CITY OF ALBUQUERQUE

May 26, 2022

Re: Champion Xpress Car Wash
5307 4th St. NW
Traffic Circulation Layout
Engineer's Stamp 05-09-22 (F14-D036A)

Sheet No.:  
**C-2.0**

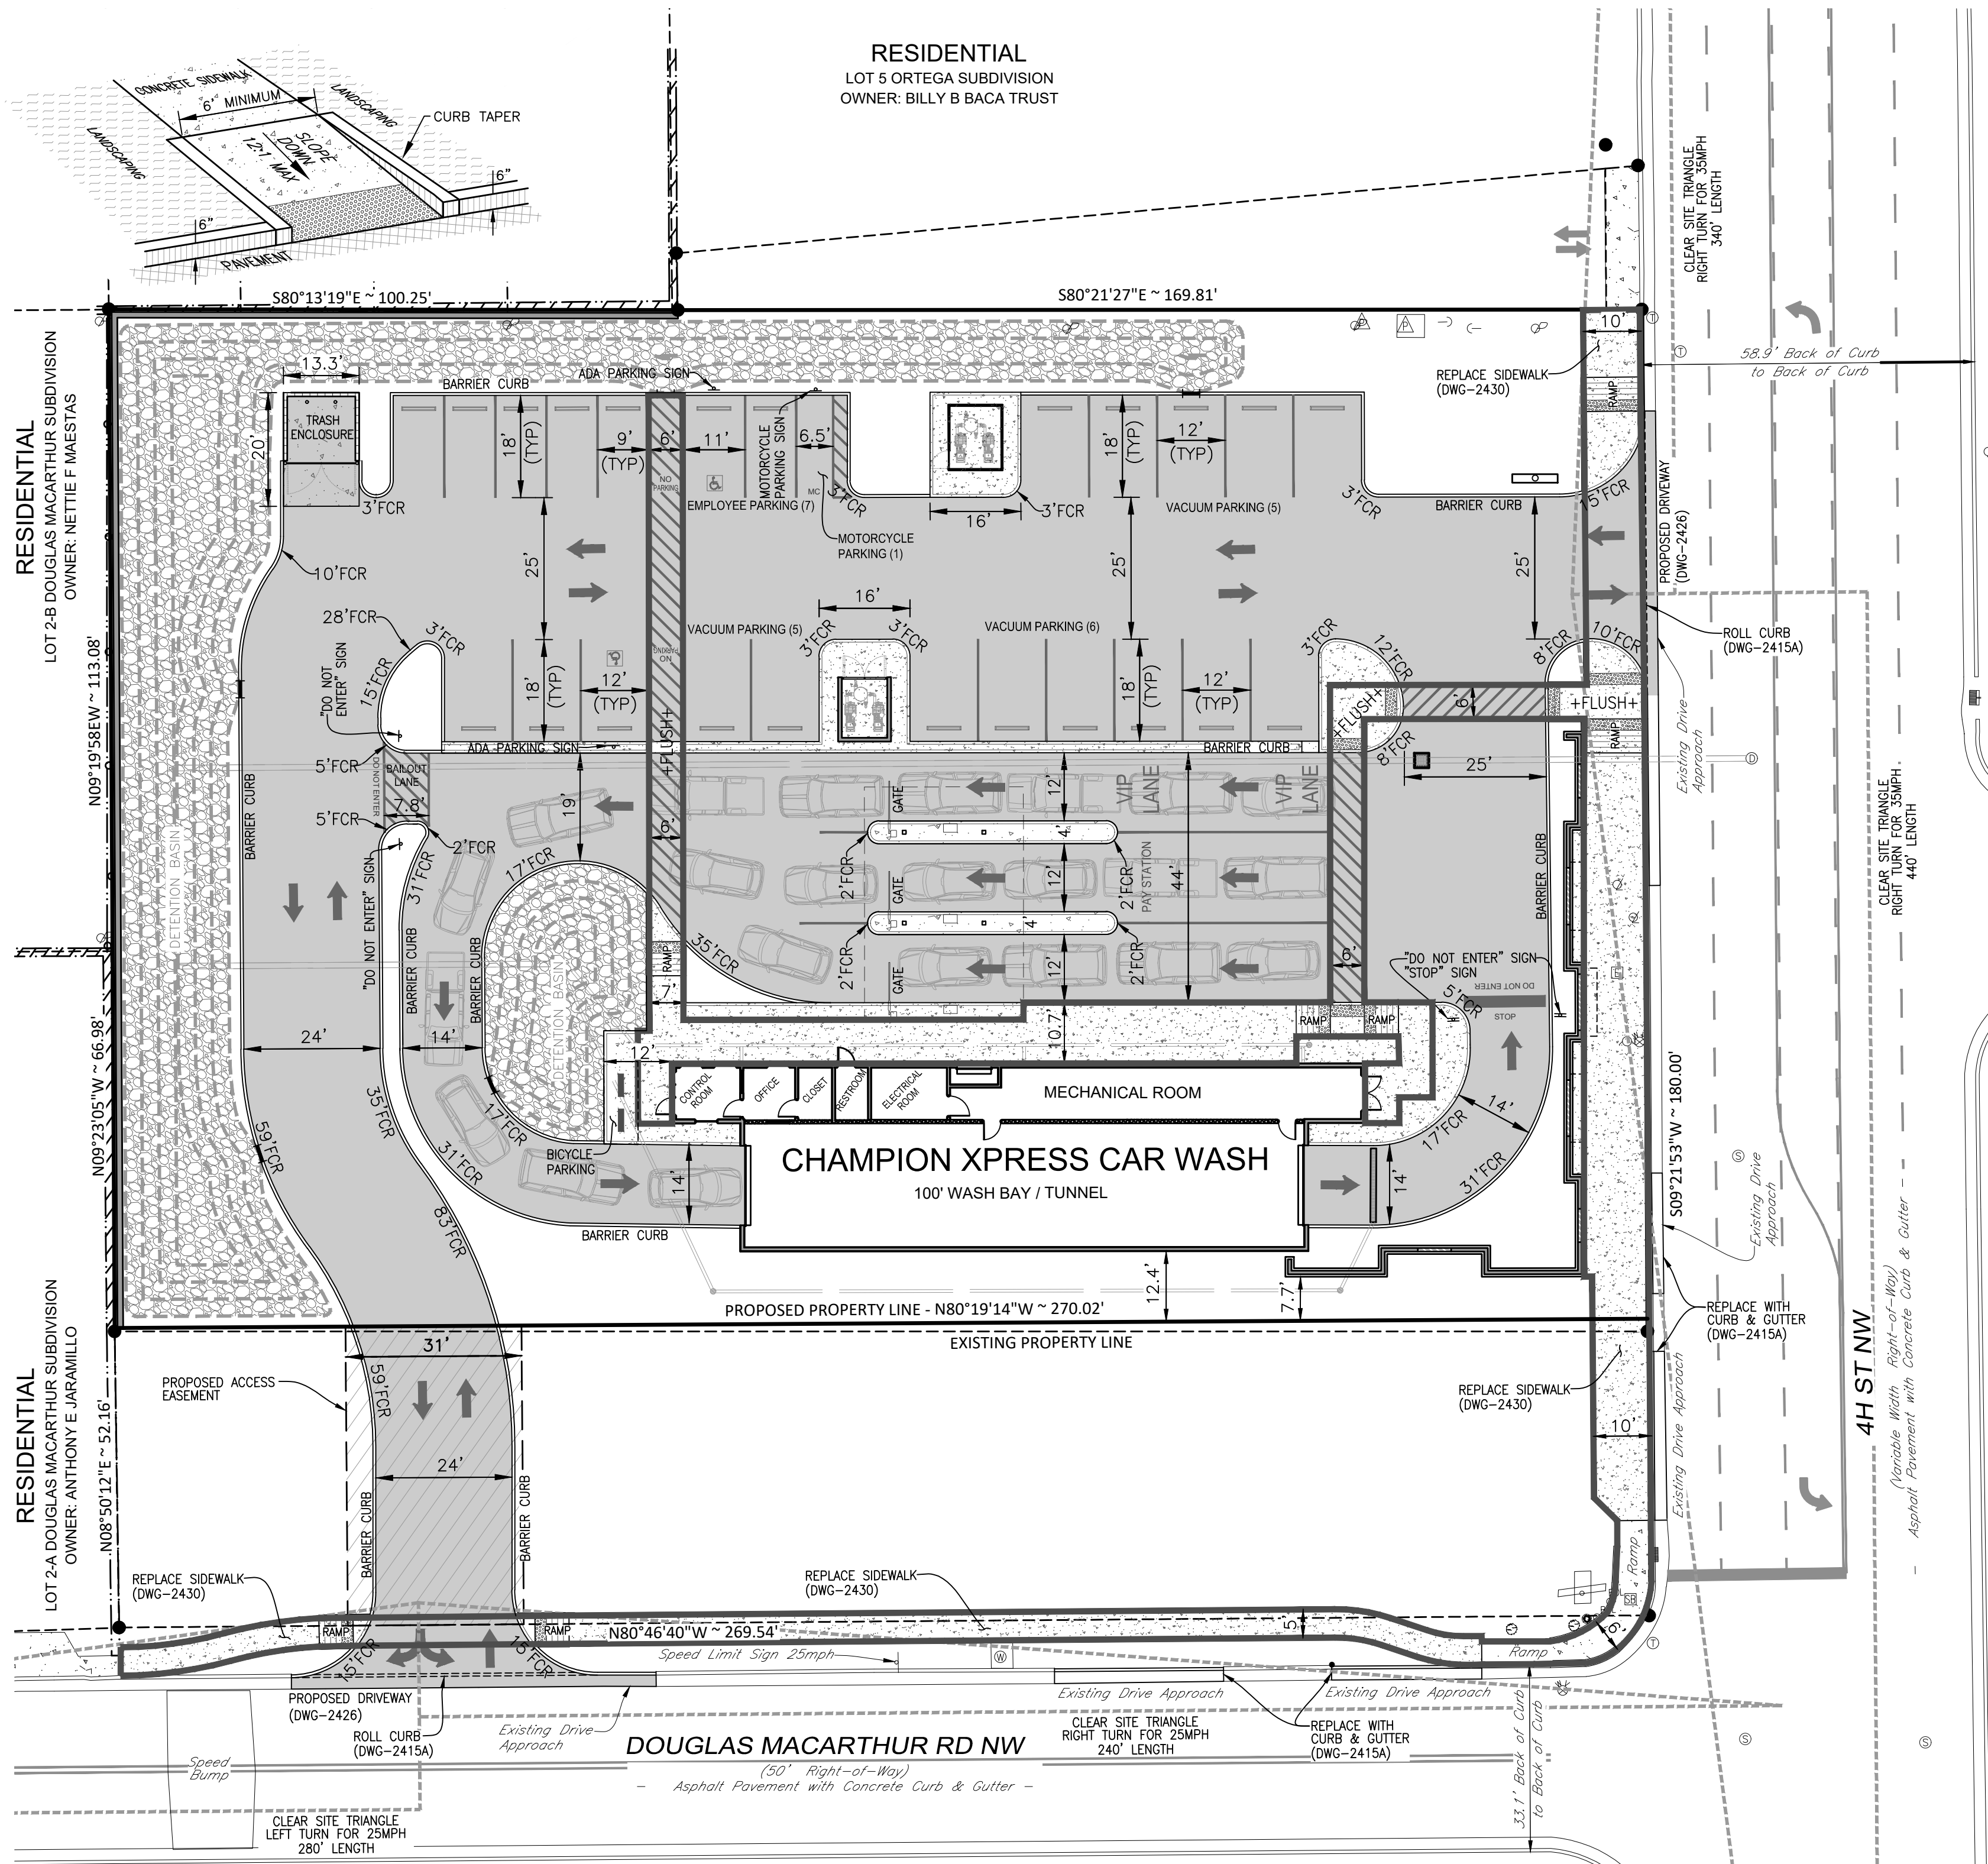
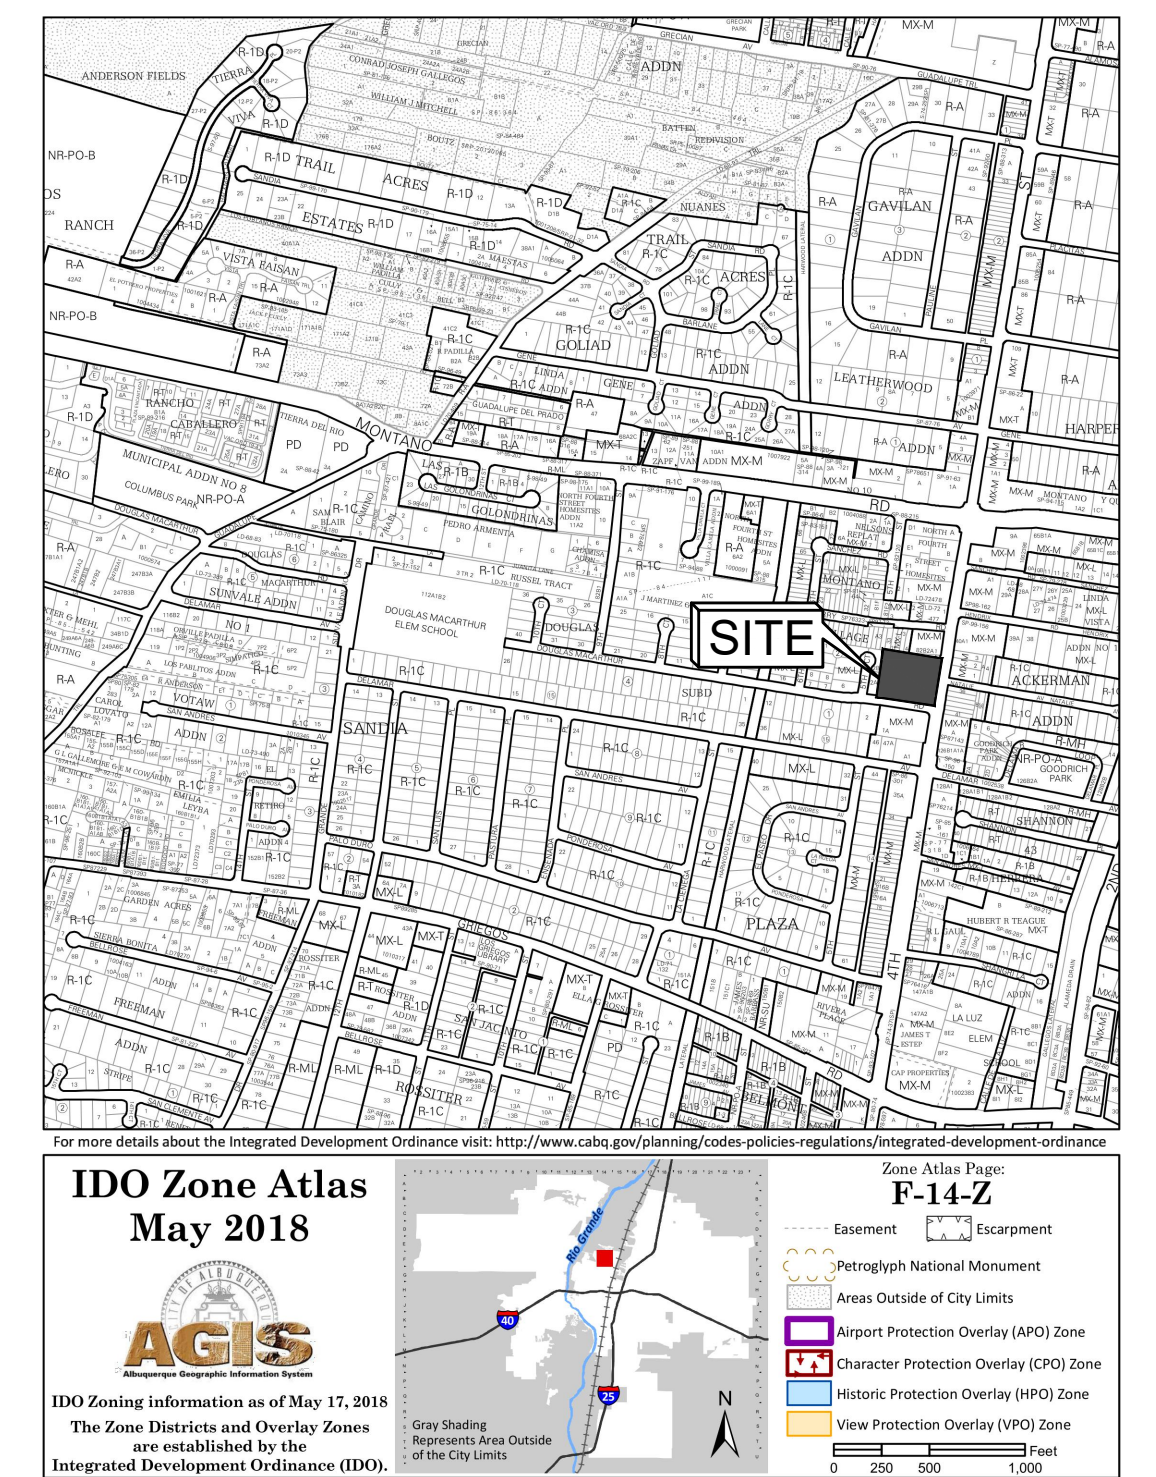
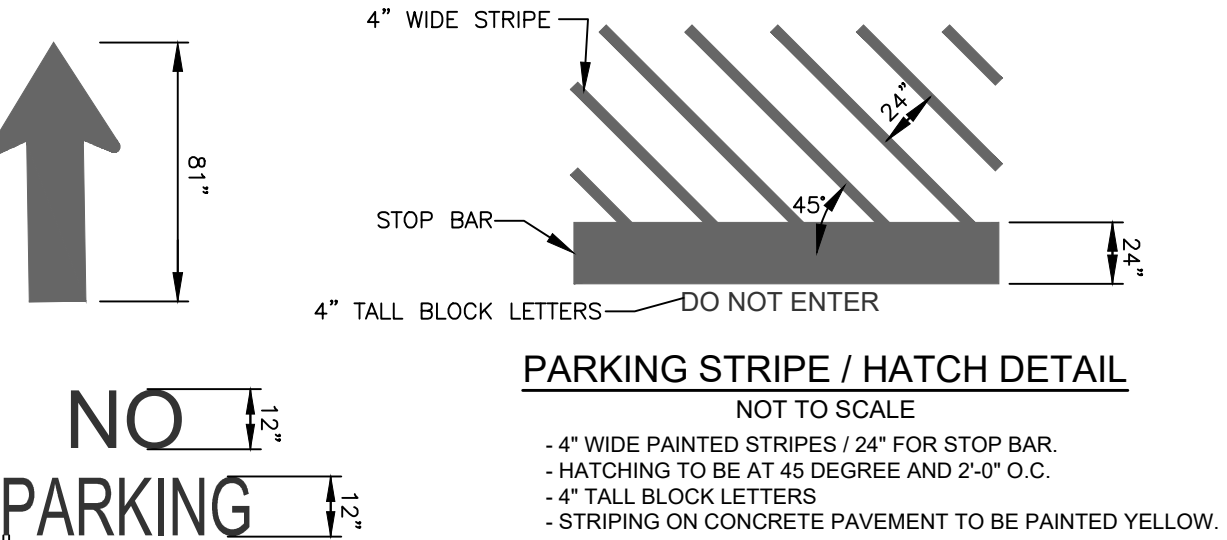
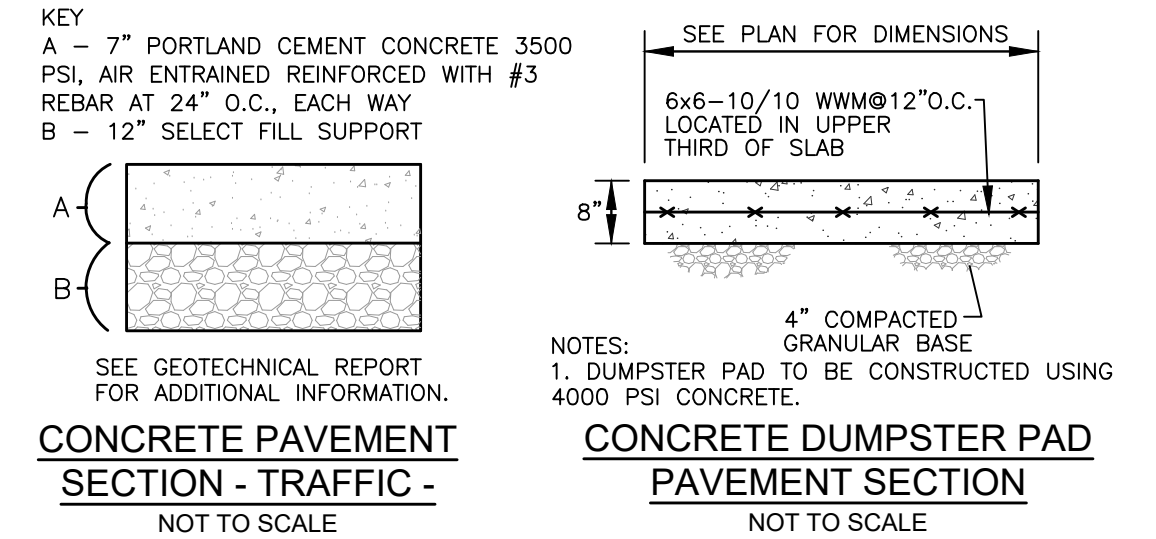
1. Provide existing sidewalk dimension.
2. Provide design details for both proposed drive accesses. And call out COA std. dwg.
3. Please specify the City Standard Drawing Number when applicable.
4. Shared Site access: driveways that straddle property lines, or are entirely on one property but are to be used by another property, shall have an access easement. Please include a copy of your shared access agreement with the adjacent property owner.
5. Unused curb cuts must be replaced with sidewalk and curb & gutter. A build note must be provided referring to the appropriate City Standard drawing 2415A for curb and gutter and 2430 for sidewalk.
6. Please Provide shared access agreement even if both lot belong to the same owner.
7. Please provide a letter of response for all comments given.

1. The existing Property line has been added and both lines are now labeled.
 2. The dimension on the 4th Street access has been added.
 3. The drive approach on Douglas Macarthur Rd has been revised to 24' wide to meet the maximum allowable width for a local street.

4. Existing and proposed drive accesses have been labeled.
 5. A chart showing the city standard details, has the Driveway Approach called out and within that drawing the details for the approach are located.

6. The words "NO PARKING" has been added to both ADA areas.
 7. The ADA ramp details have been revised to show the truncated domes.
 8. Sidewalk is placed along the East property line and the south sidewalk is placed within a sidewalk easement that will be recorded with the plat.

9. See the attached Solid waste approval. Trash enclosure location has been revised per solid waste comments.
 10. See the attached Fire 1 Plan.
 11. See the chart "City Standard Details" for city standard drawing numbers.

12. Both properties are being purchased by the developer, and as part of that they will be drafting up an Access Agreement for the lot in question once property is under their ownership.

13. Notes have been added to the areas where new curb and gutter shall be installed per city standards.
-
1. Please see attached Revised Traffic Circulation Layout.
